Waterview East Commercial  
Traffic Impact and Access Analysis  
PUDSP-22-009  
(LSC #S214970)  
July 11, 2023

LSC  
Responses  
to TIS  
Redline  
Comments

Figure 3  
Site Plan

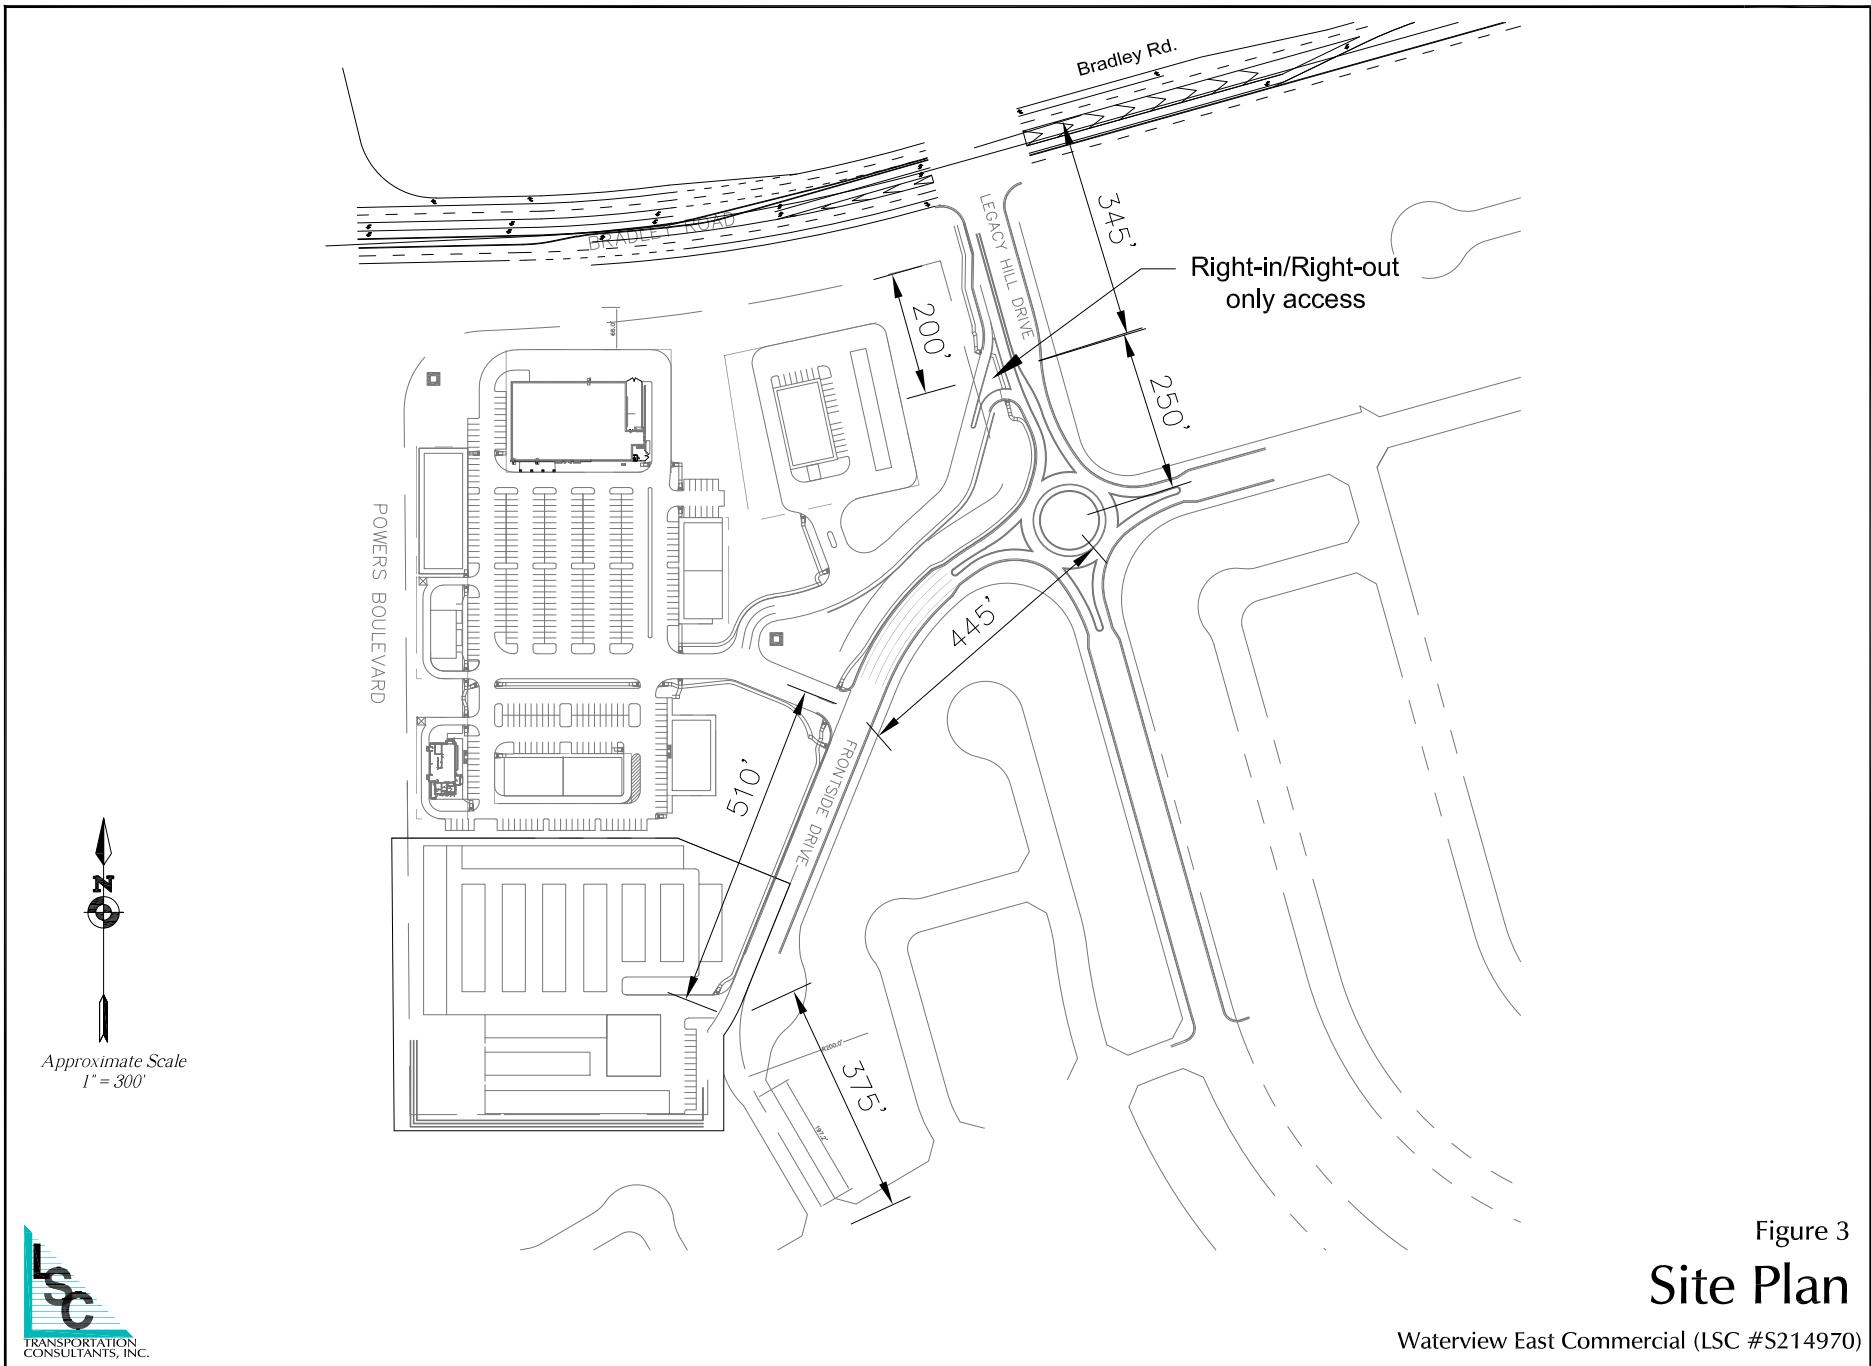
Unresolved: The original prelim and the PUDSP for Trails at Aspen Ridge anticipated a roundabout at this location. This commercial development is revising the plan to omit the roundabout. Provide analysis and discussion of the impact the current layout has in omitting the roundabout. Is the road alignment sufficient and meet all criteria or are there additional offsite improvements needed?

LSC Response: Per a phone conversation between J. Hodsdon and Ms. Durham on August 14, 2023, the report has been revised to include an additional item in the "DEVIATIONS" section of the updated TIS to address this comment and removal of the roundabout. This additional text reads as follows: "

*Note: a deviation may be required for the centerline curve radius on Frontside Drive near the south site access. Although the above explains how the south portion of Frontside Drive can be considered a "transition section" to the Urban Local street to the south (note: that the local street radius standard is 200 feet), the standard centerline radii is 565-feet on a Non-Residential Collector street. The Preliminary Plan shows a 200' radius. After a brief discussion with staff on August 14th, it was agreed that a deviation, if needed, be prepared later in conjunction with the design of Frontside Drive. It our understanding that the Trails at Aspen Ridge developer is responsible for the design of Frontside Drive as part of the final plat of the adjacent land. Any required, associated deviations would be submitted at that time, with the plat and/or street design plan submittal.*

Author: jchodsdon      Subject: Sticky Note      Date: 8/15/2023 1:09:07 PM  
LSC Response: Please refer to the response to the above comment.
